**Re: Dutch Brothers Coffee – 2131 Gibson Blvd SE  
Erosion and Sediment Control Plan  
Engineer's Stamp Date 12/9/2022 (M15E021C)**

Based upon the information provided in your submittal received on 12/09/2022, the above referenced ESC Plan cannot be approved until the following comments are addressed.

Title:  
EROSION AND SEDIMENT CONTROL PLAN  
SWC GIBSON BLVD AND YALE BLVD  
ALBUQUERQUE, NM 87121

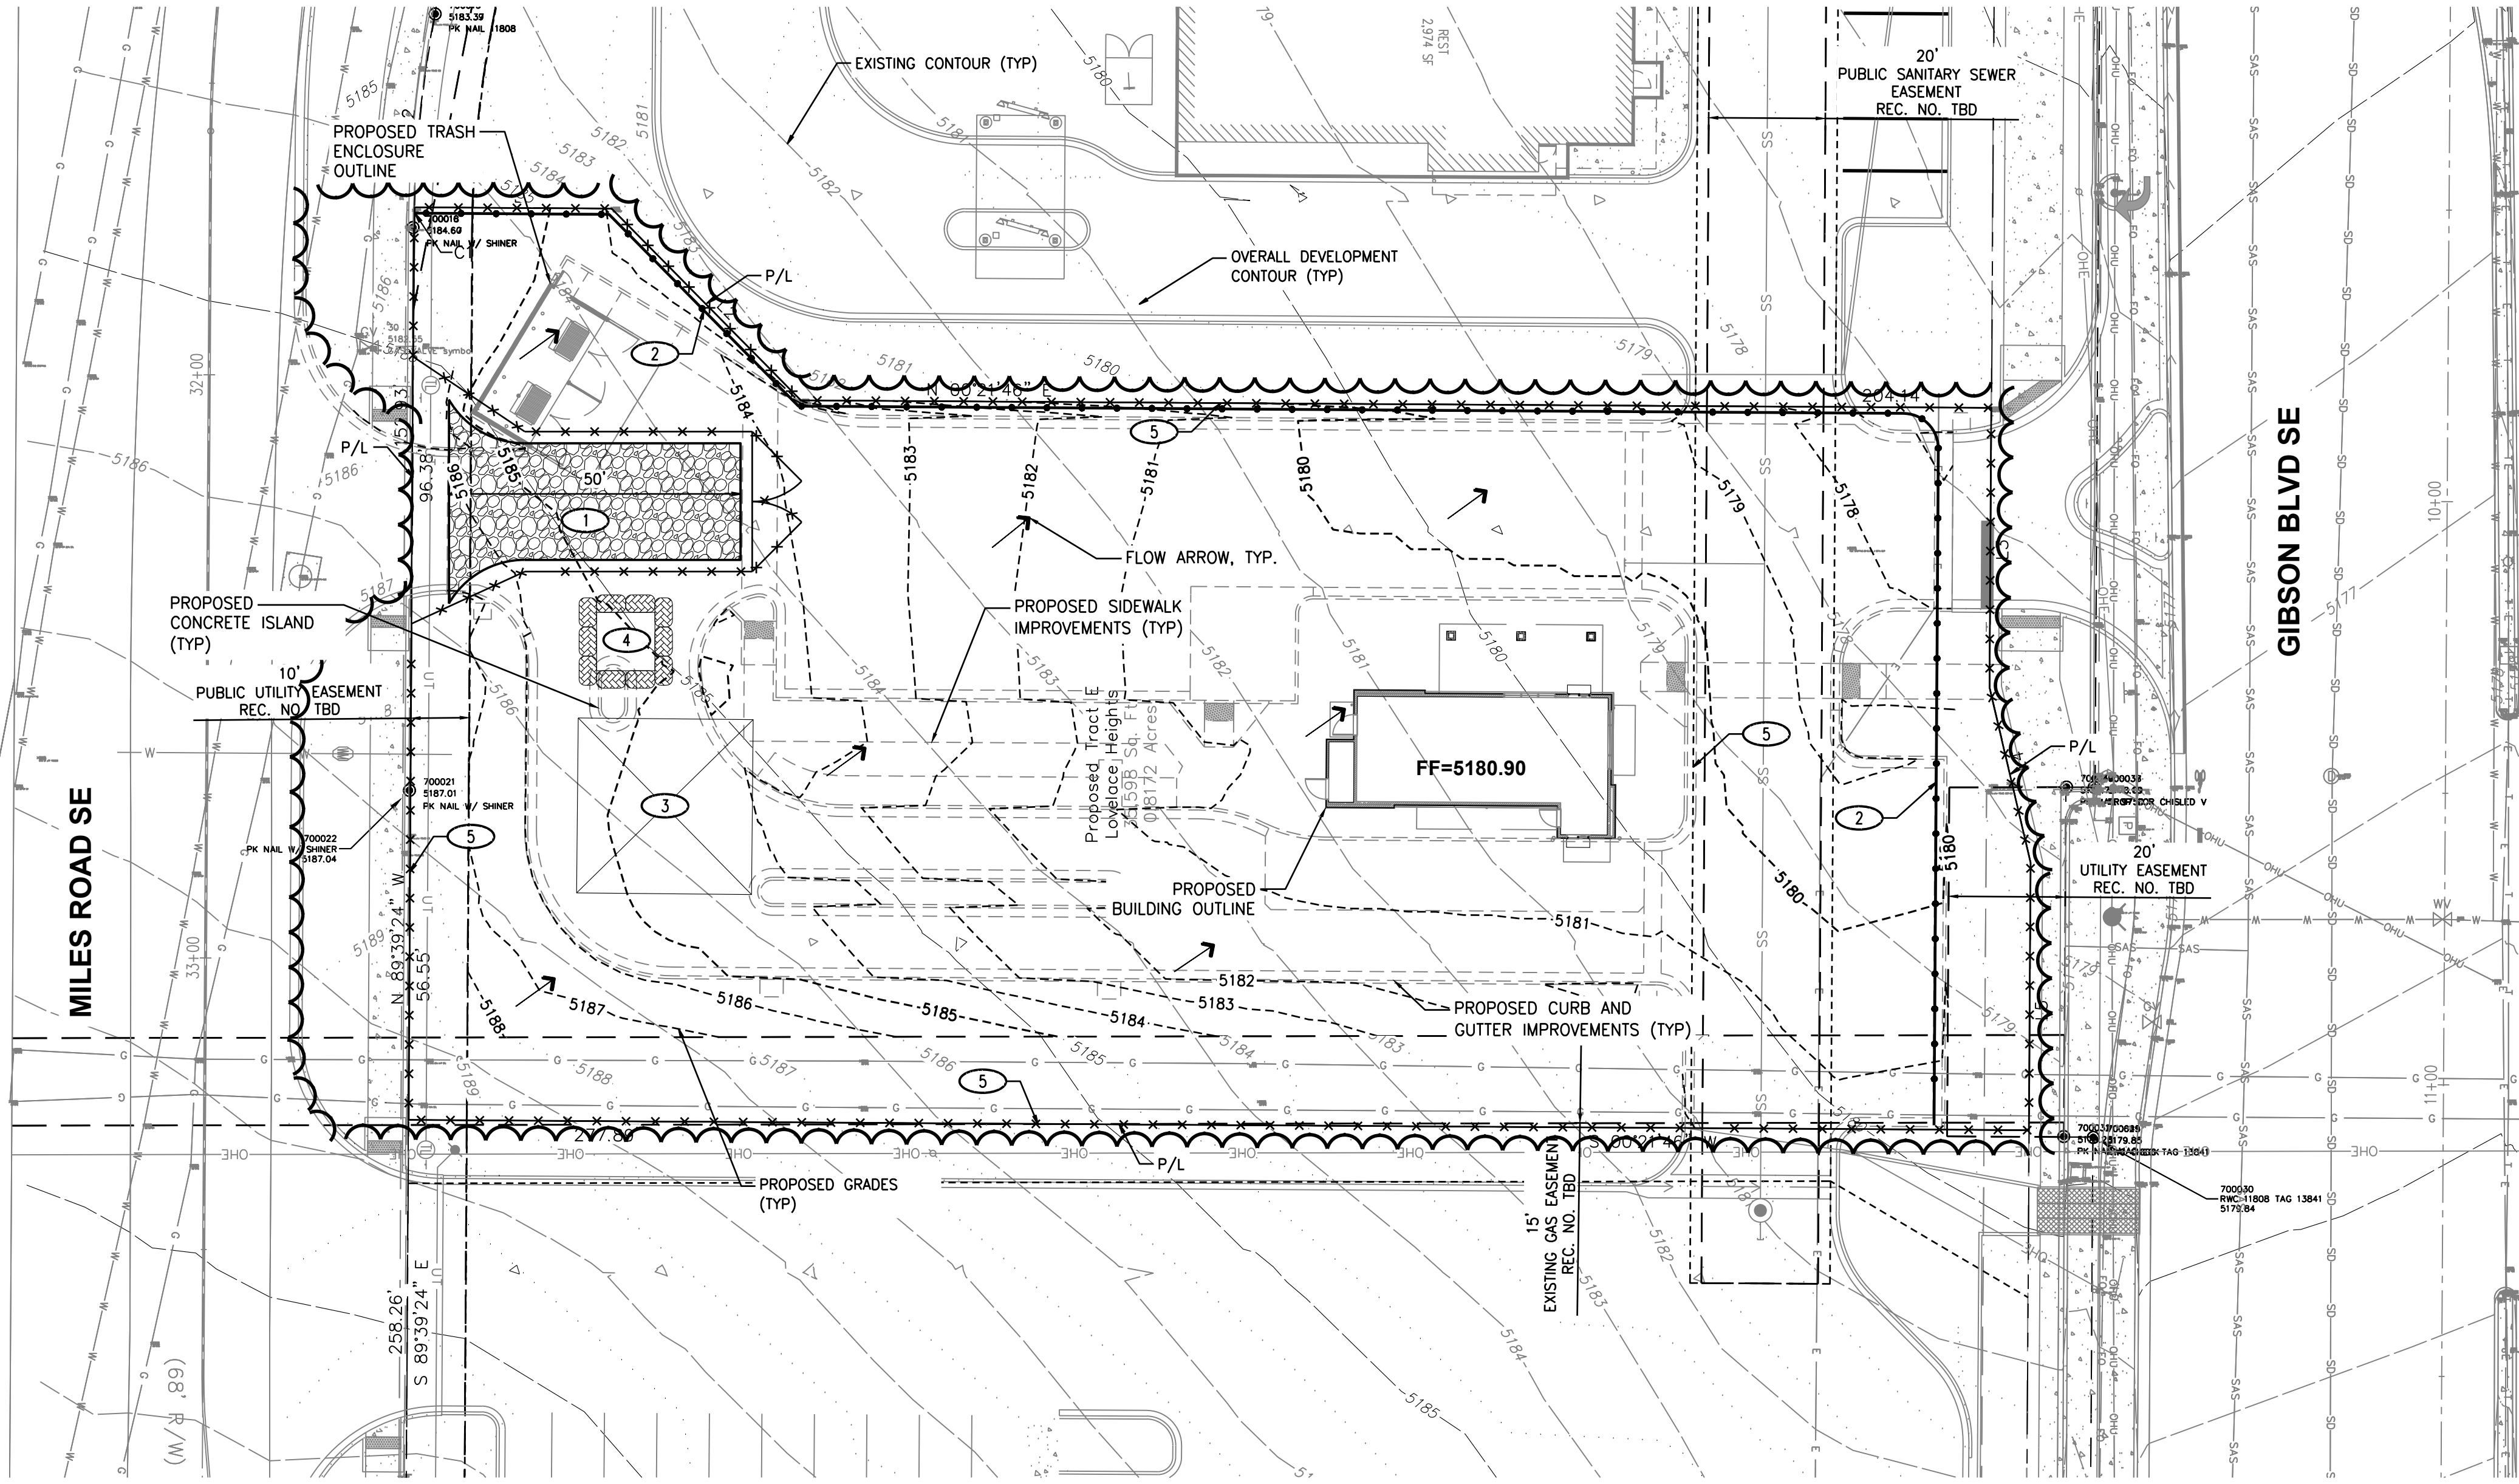
1. The ESC Plan can't be approved until after Hydrology approves the G&D Plan. The existing and proposed grades must be shown on the ESC Plan, and they must agree with the Grading Plan approved by Hydrology (CGP7.2.4.b.ii).

2. Show all structures on the ESC Plan including the building, sidewalk, and asphalt.
3. This site is part of a "Common Plan of Development or Sale" that exceeds 5 acres, so permit coverage is required even if the site is less than 1 acre and waivers are not available. The ESC Plan can't be approved for Grading or Building Permit until the property owner's NOI has been reviewed and approved by City Stormwater Quality per Albuquerque Code § 14-5-2-11(a). The NOI must be in the SWPPP and available onsite (CGP7.3).

4. Describe the nature and extent of construction activities (CGP 7.2.2.). Include a description and project schedule per CGP 7.2.3.f starting with installation of the BMPs, posting a sign, and demolition of existing AC, through final stabilization, removal of BMPs, and filing NOT.

5. Update the engineer's stamp date each time the plan is changed.
